DELEGATED REPORT

APPLICATION NUMBER	S6/2004/0873/FP and S6/2004/0849/LB
LOCATION	The Accommodation Block, Astwick Manor, Coopers Green Lane, Hatfield
PROPOSAL	Conversion of building into one 1 bedroom and five 2 bedroom apartments with 12 parking spaces

24903/101

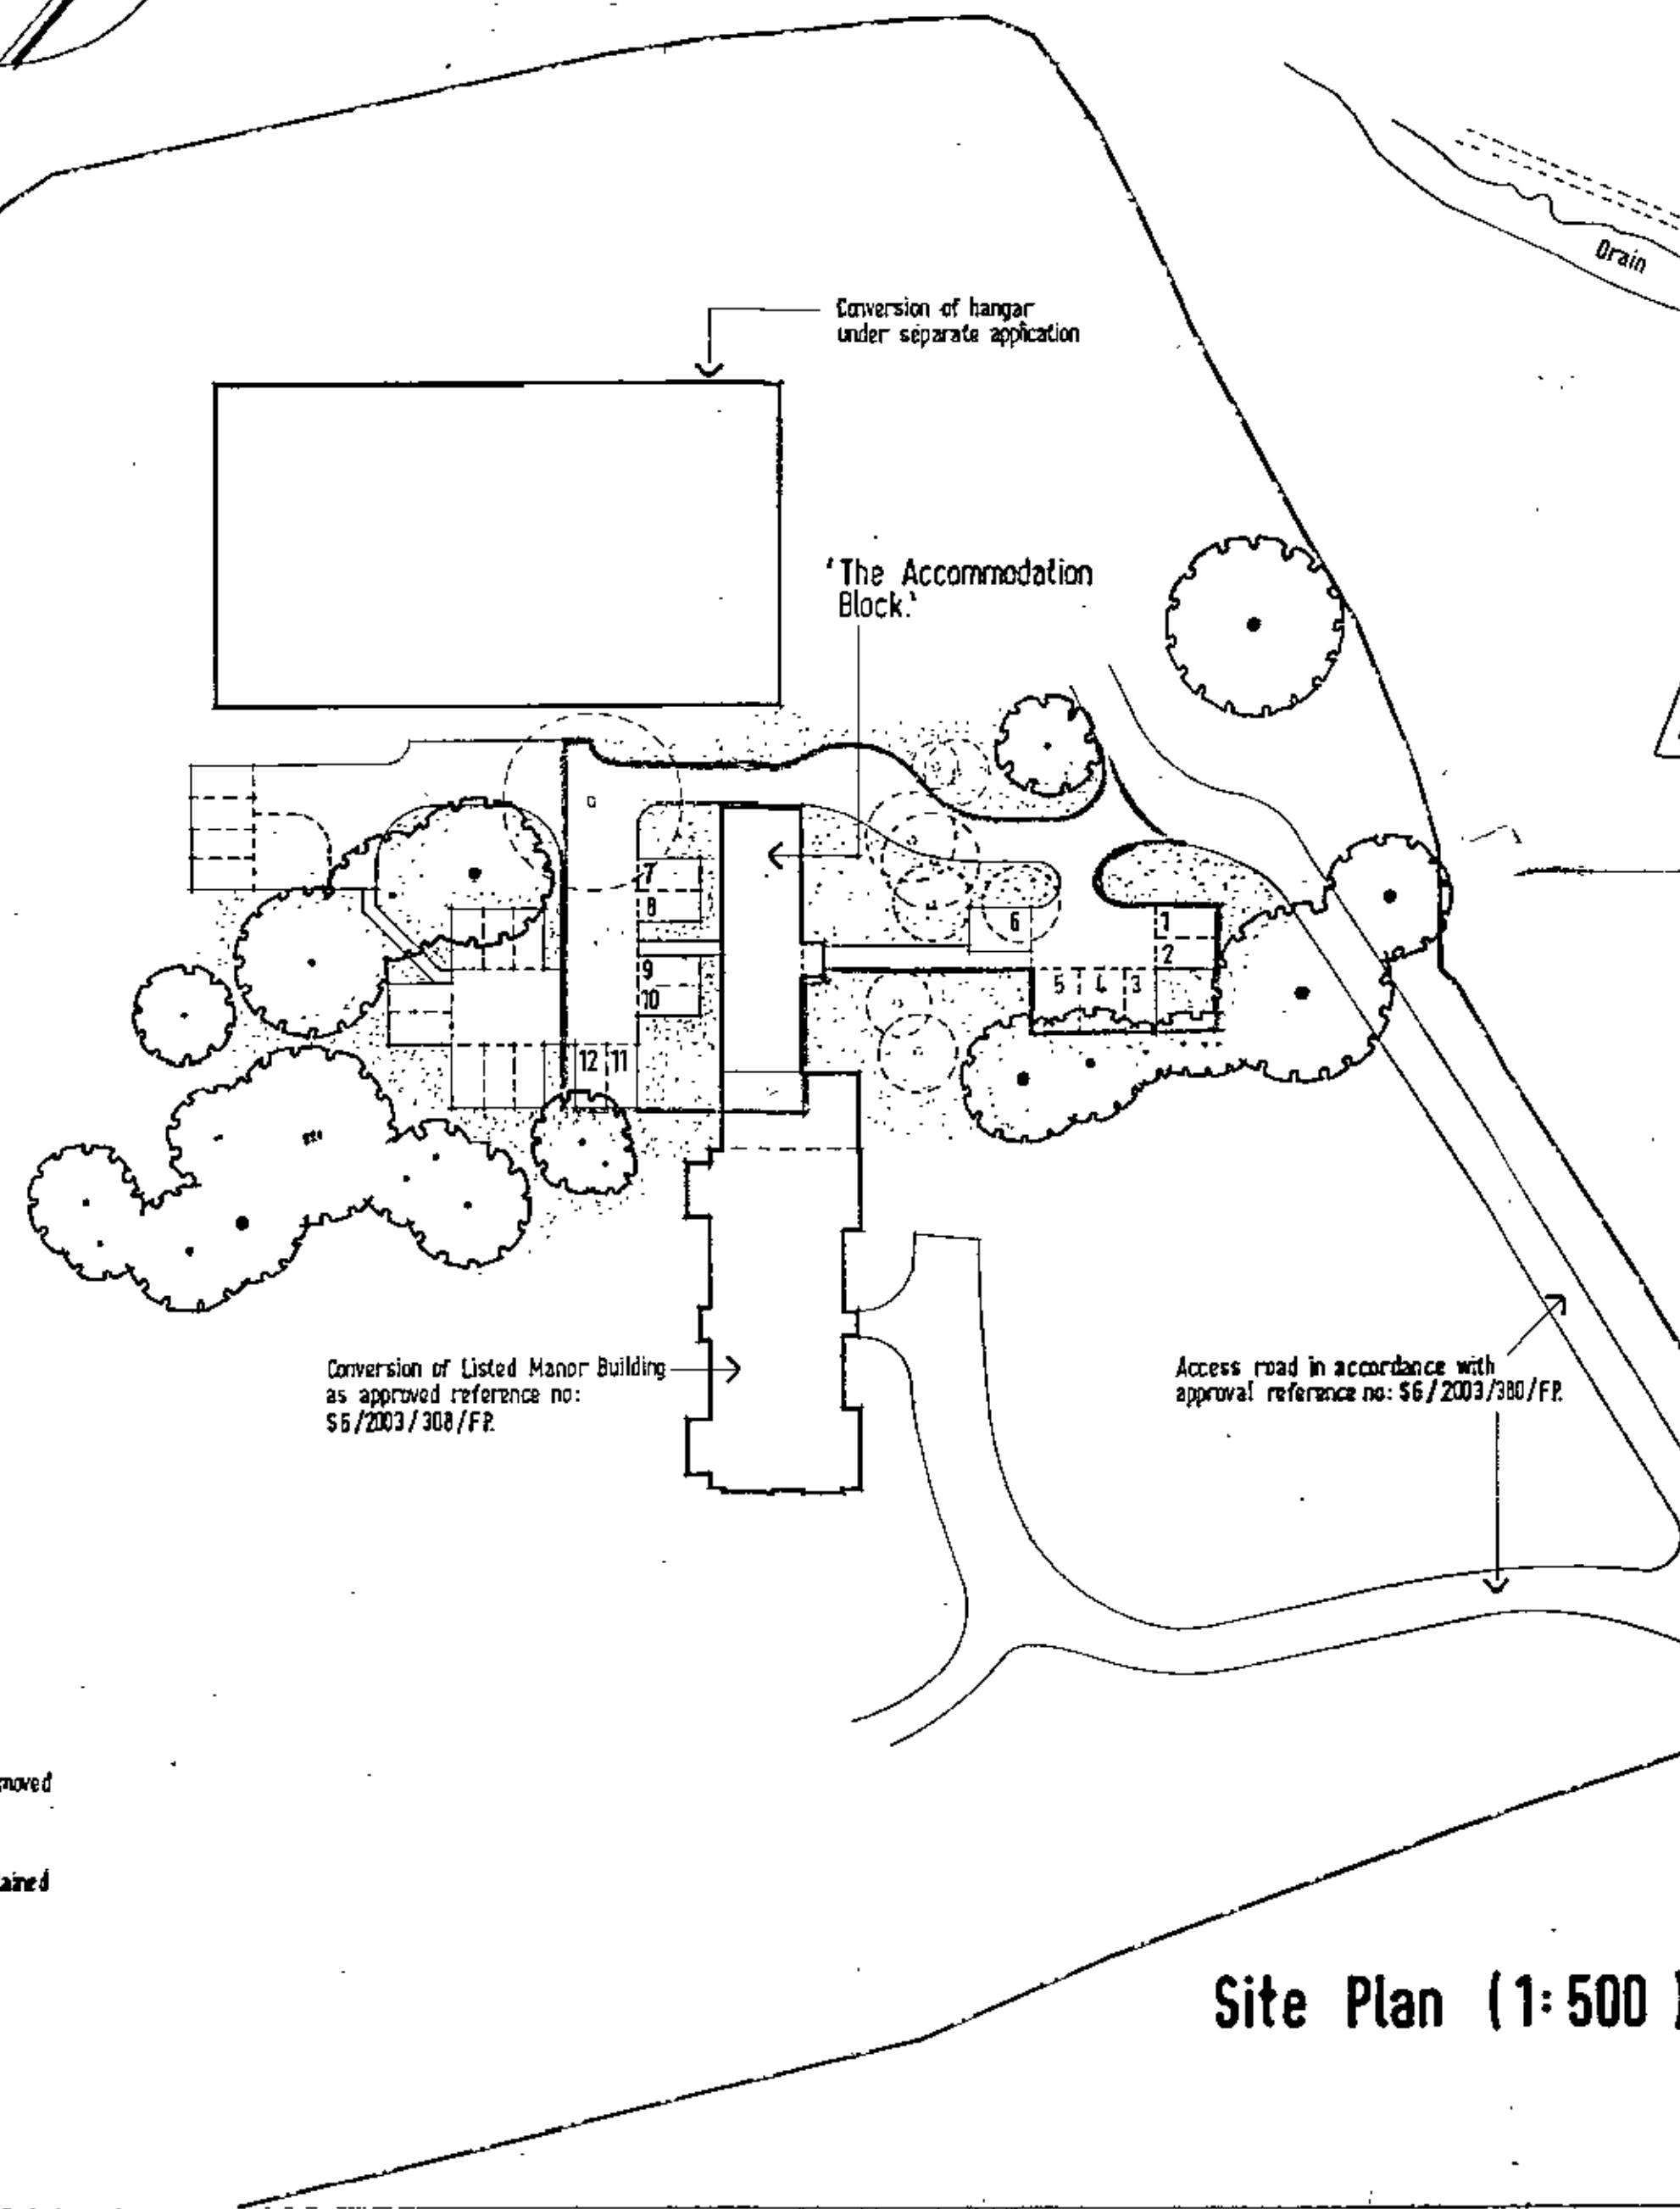
- Internal layout modified from that approved by S6/2003/380/FP (NB no additional residential units proposed)
- Parking for 12 cars to be as indicated on drawing 24903/101

Traffic, Highways and Parking - the application seeks approval of 12 car parking spaces to be located in new parking areas. Condition 6 imposed on S6/2003/380/FP required a scheme for a less formalised approach to parking to be submitted to and approved by the LPA. The parking arrangement proposed for the accommodation block (drawing no 24903/101) is considered acceptable. This scheme will not represent a change to the previously approved access arrangements but will not supersede the requirement for improvement works to be carried out to the junction between the access road to the site and Coopers Green Lane. For the purposes of consistency and to prevent implementation of a consent without the necessary road junction improvements, Condition 3 of S6/2003/380/FP is to be imposed here.

3. The parking spaces shown on the plan hereby approved shall be provided and marked out prior to the occupation of any buildings on the site, and shall be retained and kept available for those purposes thereafter.
